20240529-ABP-315708

RE: Response to request for submission on further information; Patrick Bonar Quarry application; Raphoe, Co. Donegal

Ref: ABP-315708

For: Demolition of existing concrete structure and the quarrying of 5.37 hectares which will be subject to extraction and processing of rock through drilling, blasting, crushing and screening and all associated ancillary facilities/works over a 25 year period. An Environmental Impact Assessment Report and Natura Impact Statement accompanies this application.

Job Number 19280 Dwg Number 09

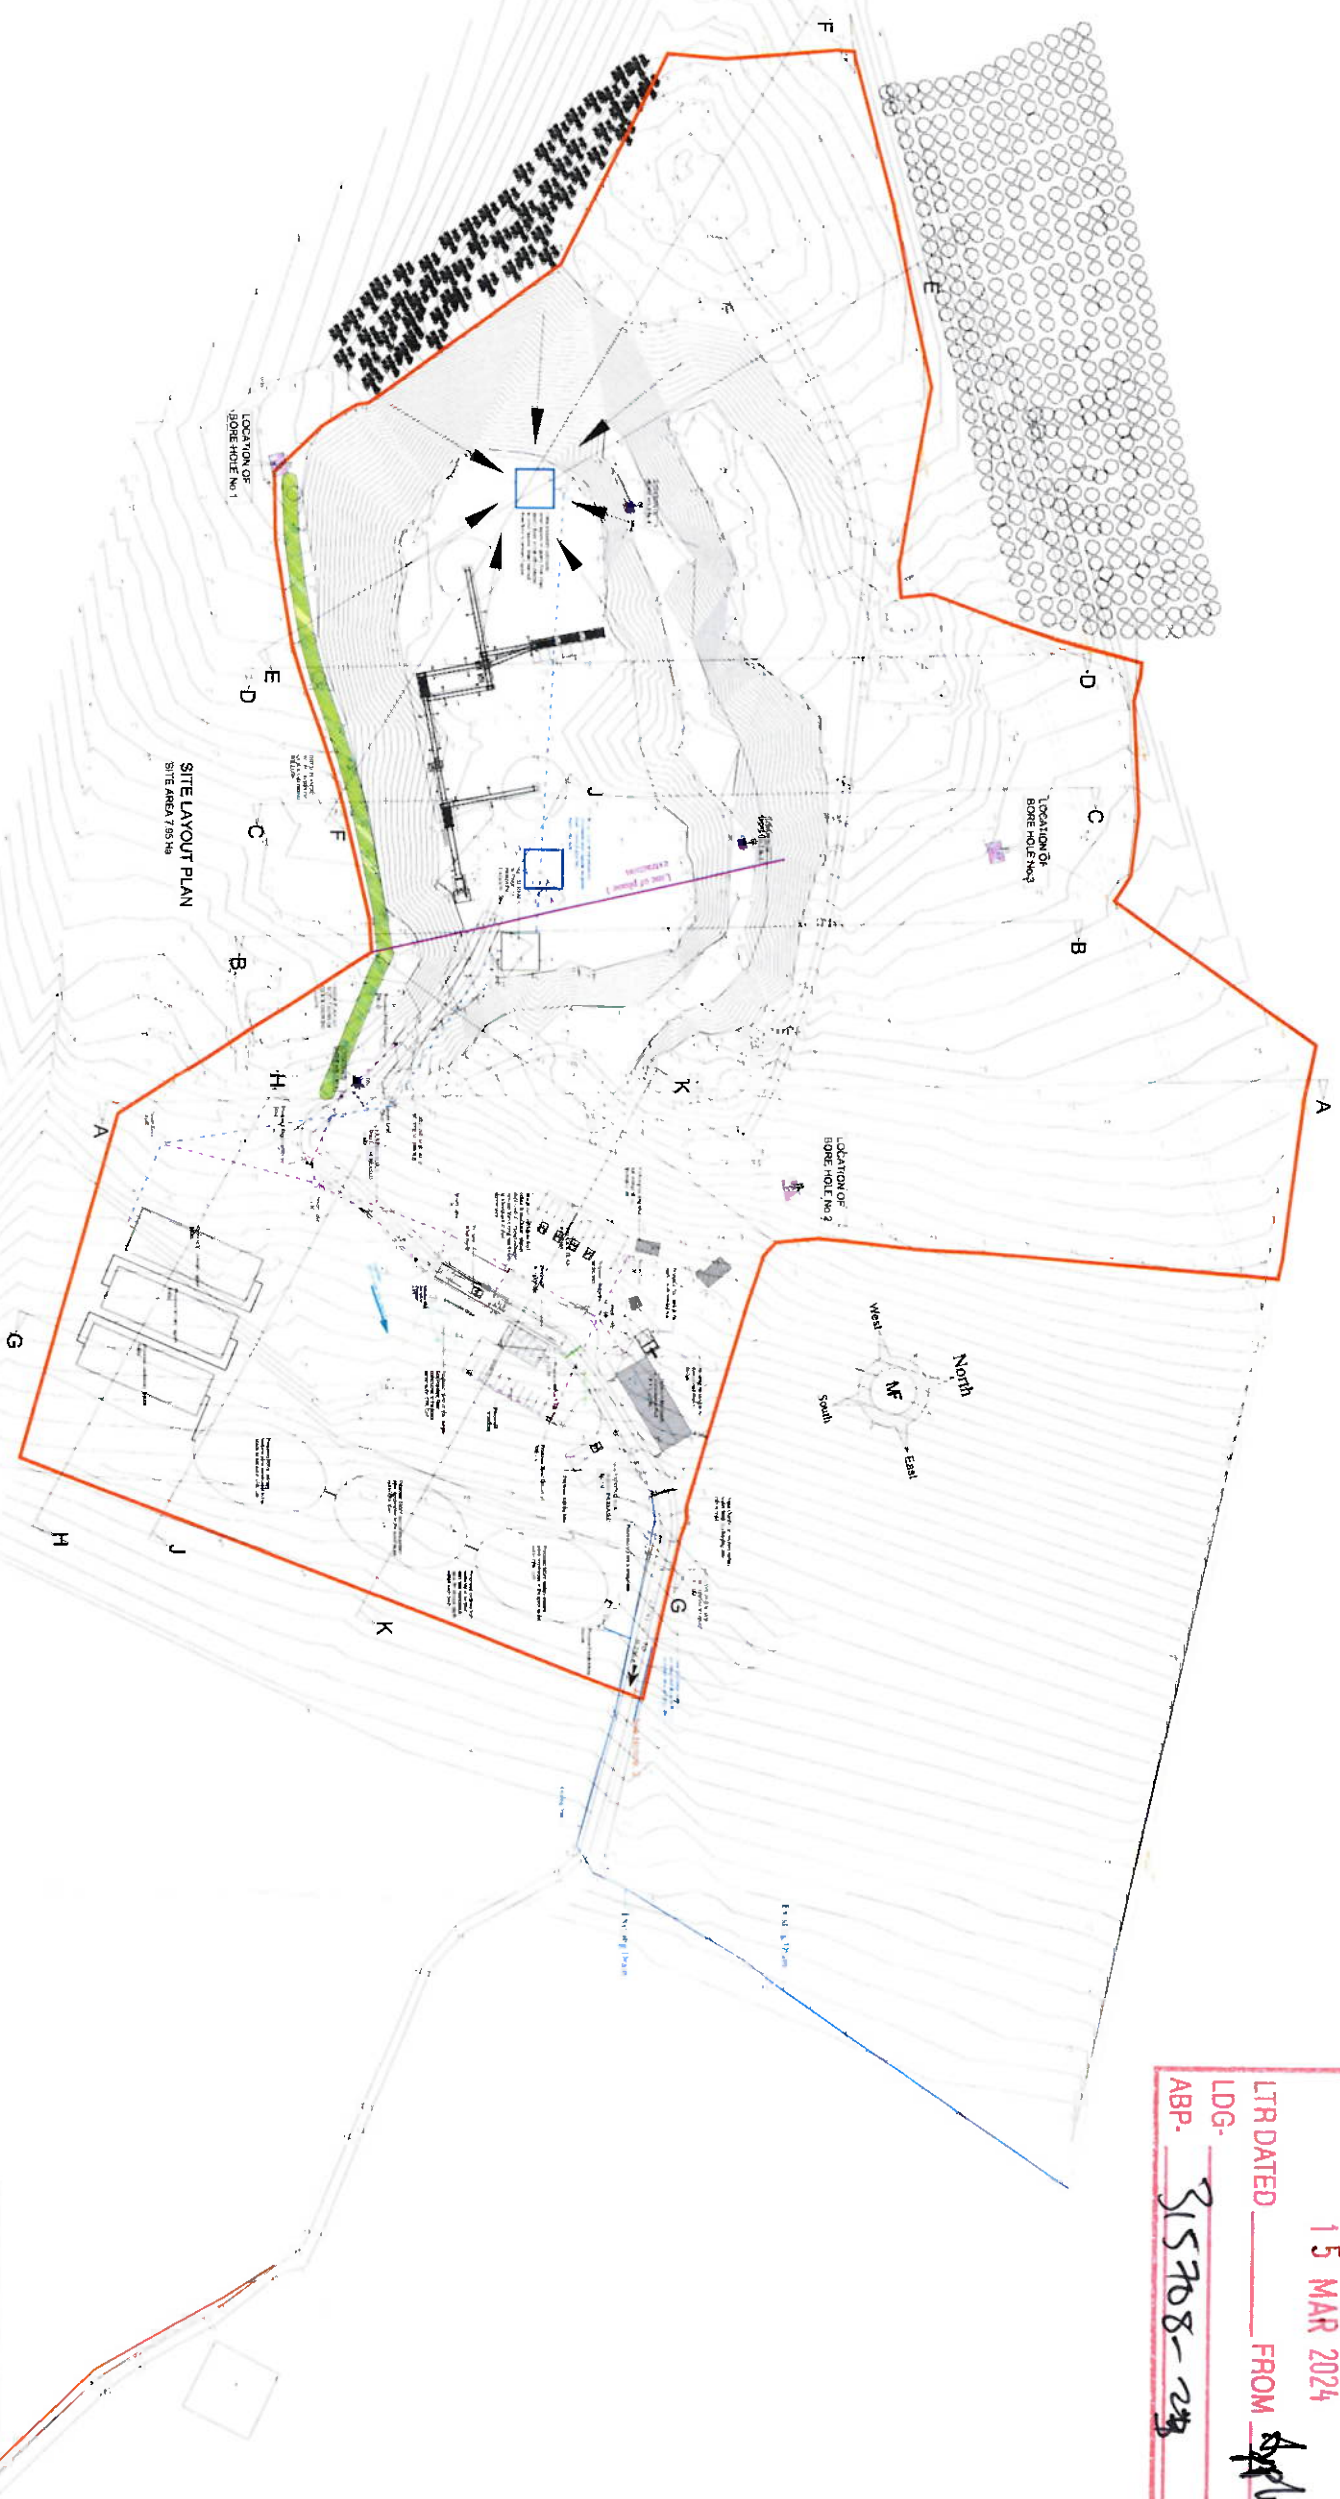
It is submitted that the proposed complex three-stage process has not been demonstrated to be compatible with the ongoing excavation envisaged or having capacity to address extreme rainfall events on a site which has a significant gradient, as shown in general arrangement drawing no. 09 by Michael Friel.
